From: [Carol Branigan](#)
To: [Cynthia Palmer](#)
Cc: [Planning](#)
Subject: RE: 6/2019/0217/MAJ Northaw House Coopers Lane Northaw Potters Bar EN6 4NG Conversion of Northaw House to form 11 apartments (including refurbishment of existing single caretaker's flat) and underground parking area, the Ballroom Wing to form 2 dwellings,
Date: 29 May 2019 21:04:29

Application Reference: 6/2019/0217/MAJ

Proposed development at: Northaw House Coopers Lane Northaw Potters Bar EN6 4NG

Response to correspondence from Tim Waller, Waller Planning

Project Ref KMC-02	Rev 01
-----------------------	-----------

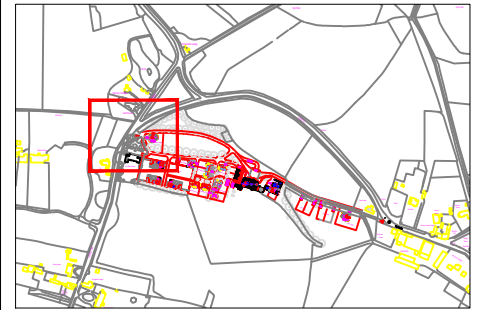
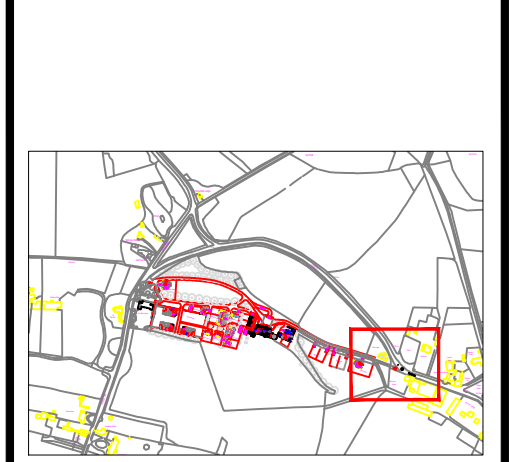
the site. We question the statement 'residential use would generate around 3 inbound trips and 10 outbound ones in the morning peak hour' when there are 27 dwellings, including family dwellings, proposed. Vehicles would be essential for commuting to work and for the school run at this time in the morning and, given the poor bus service and unsuitability for cycling due to topography and heavy existing traffic it is hard to see how this equates to only 10 trips. It is several years since the house was used as offices and in the intervening period the road has become much busier with considerably more HGV traffic, which calls comparison with this period into question. The existing junction and the proposed junction at the east end are both hazardous.
